**Consultation Response from KC,
Highways Development Management****2025/92156 Land at, Lingards Road, Slaithwaite, Huddersfield, HD7 5HY****Erection of 3 apartments (Class C3) with associated amenities (modified proposal)****Date Responded: 11-9-2025.****Responding Officer: Mark Berry.****Responding Ref: 1-32-20.**

The proposal is to modify plot 27 which was shown to be a 4 bedroomed detached house with integral single garage on the approved 2020/93954 layout and provide 3 two bedroomed apartments.

drawing no.: 2510-PL-27-120 rev: -

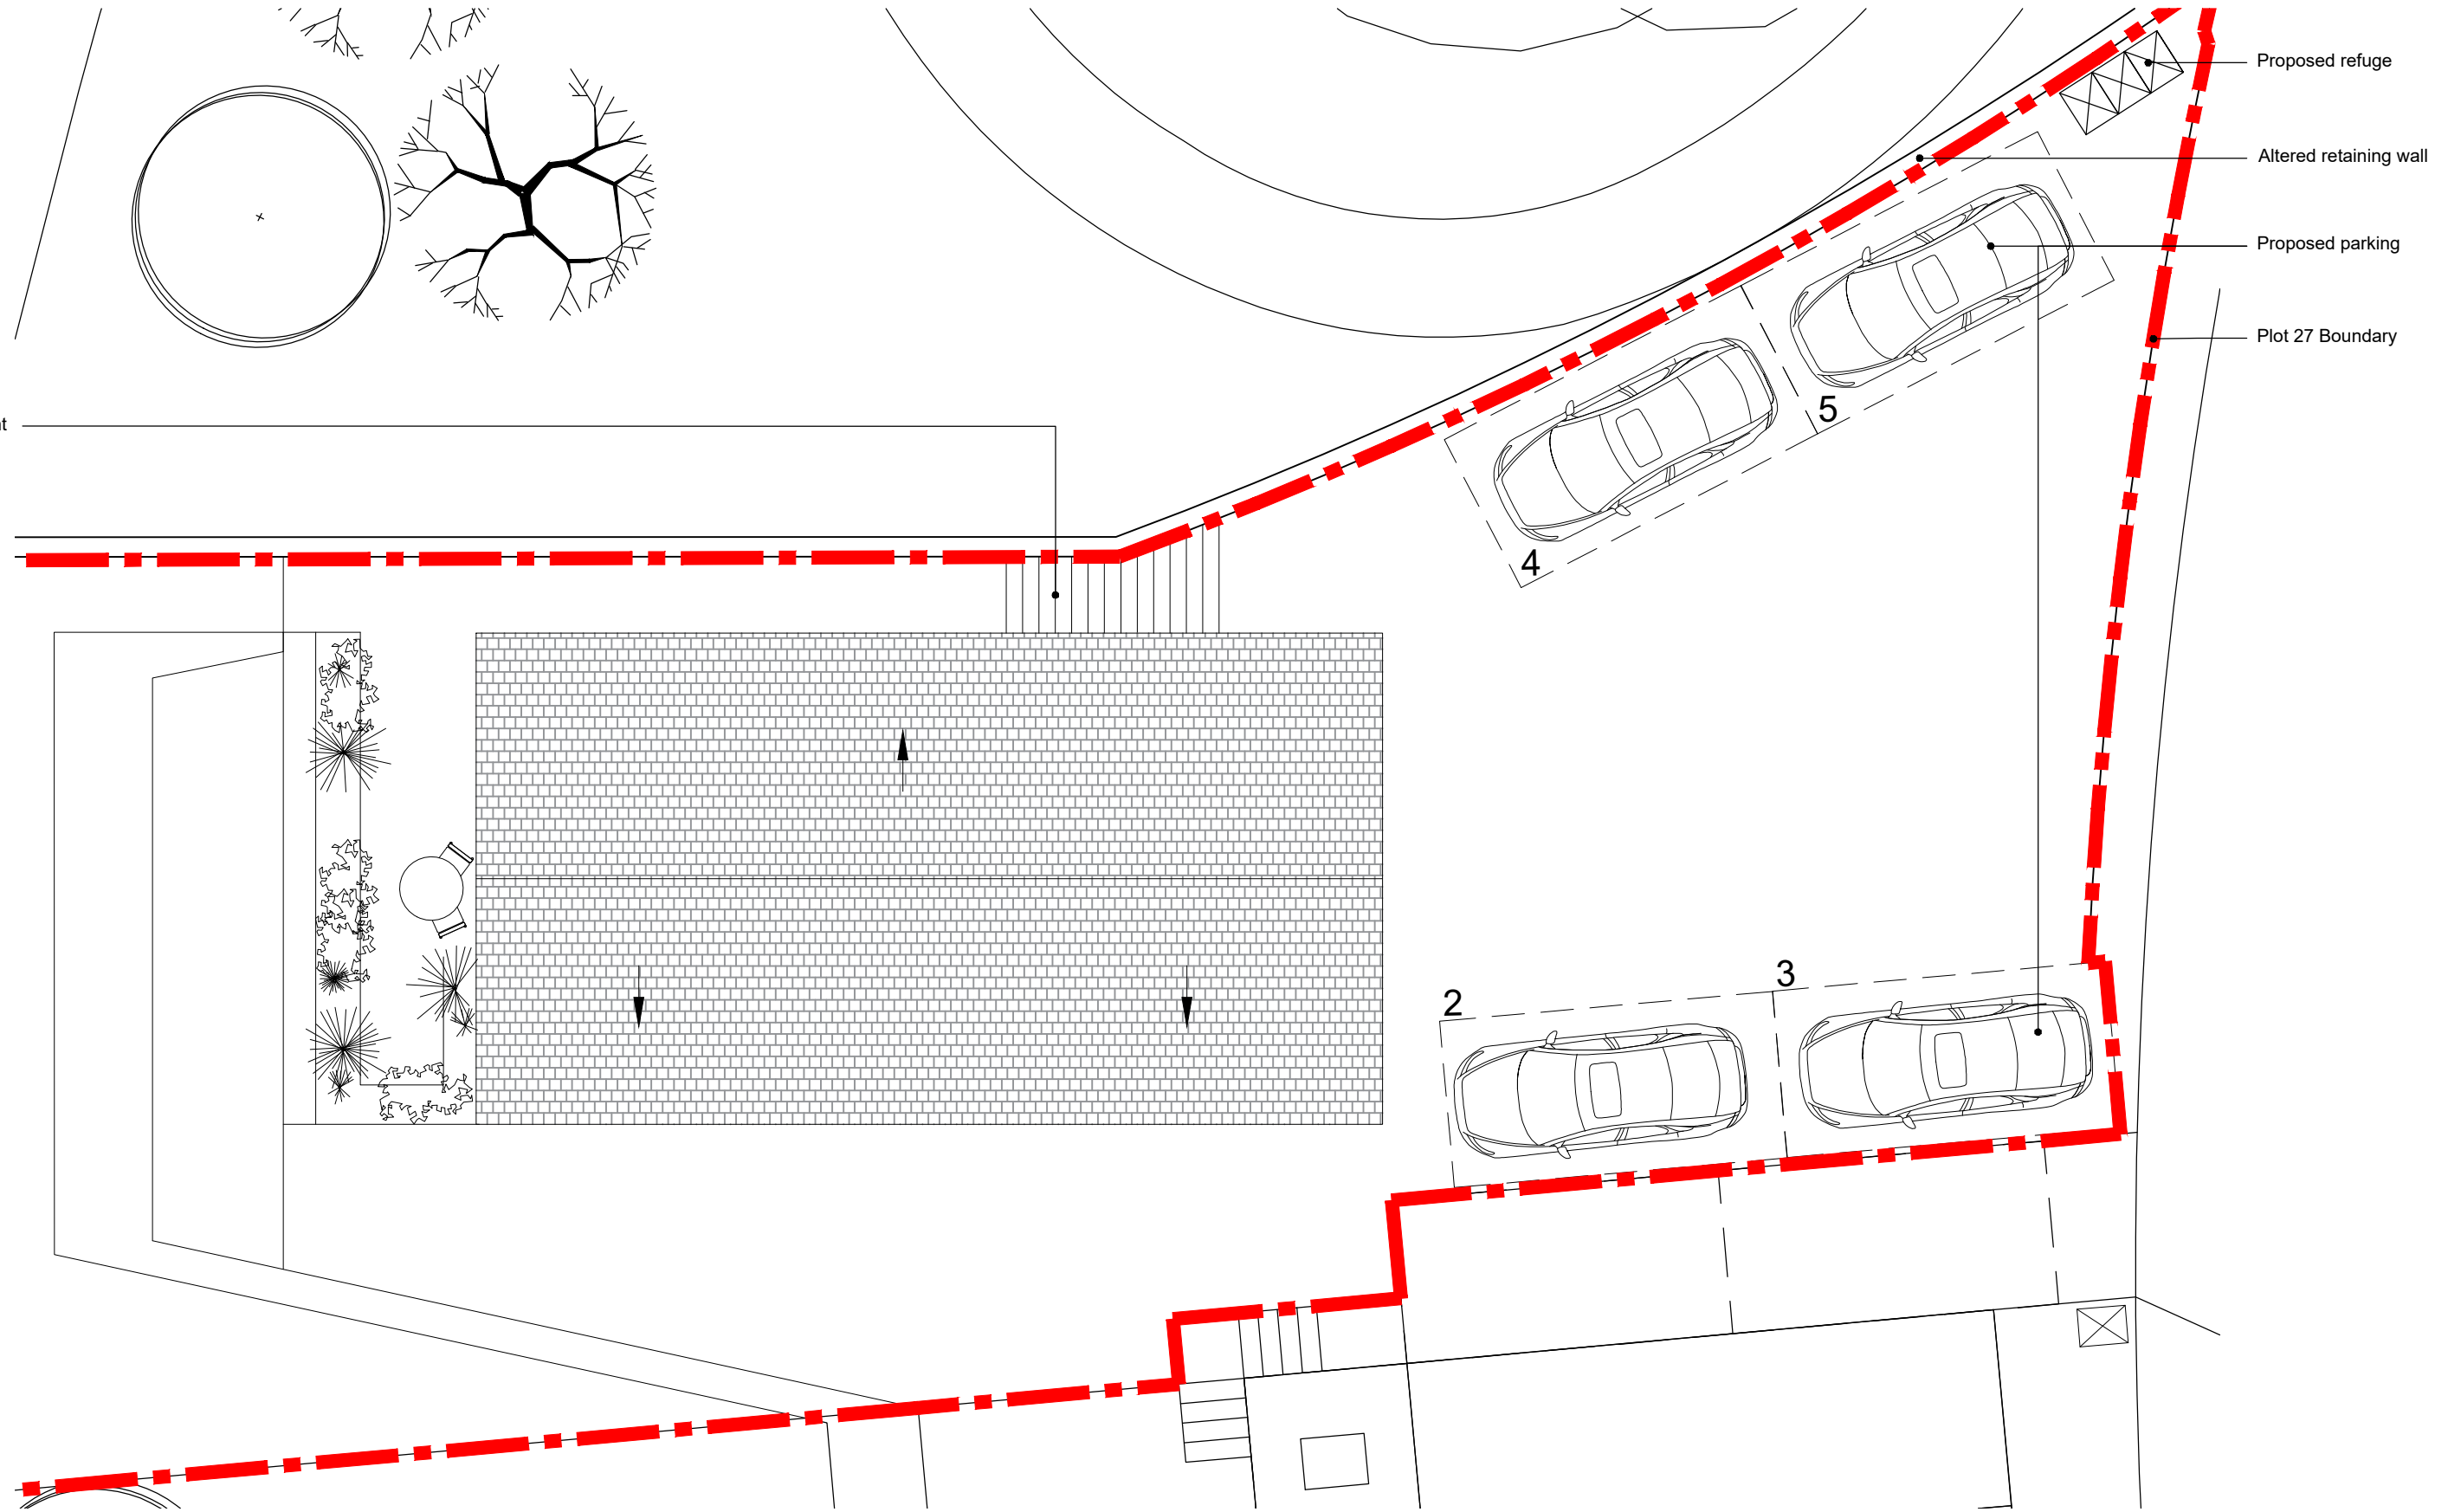
The Proposed Site Plan number 2510-PL-27-120 shows 4 parking spaces to the front number 2 to 5. The ground floor plan number 2510-PL-27-100 shows a single integral garage to apartment 1.

The Proposed Site Plan provides insufficient detail. The road and footways to the site frontage are not shown.

The driveway to the proposed integral garage is not shown.

Parking spaces 4 and 5 are shown up against the repositioned eastern boundary and meet the proposed access road at an acute angle which could result in difficult turning and manoeuvre. The proposed bin collection point will also obstruct the access to these spaces.

No details of sight line from the parking spaces onto the proposed estate road are shown. This is a particular concern at the eastern boundary where a retaining wall is shown.

HDM would ask the applicants to provide a revised plan showing more detail including road and footways to the site frontage, the parking to the eastern boundary re-positioned, access to the proposed integral garage and the proposed sight lines onto the proposed estate road.
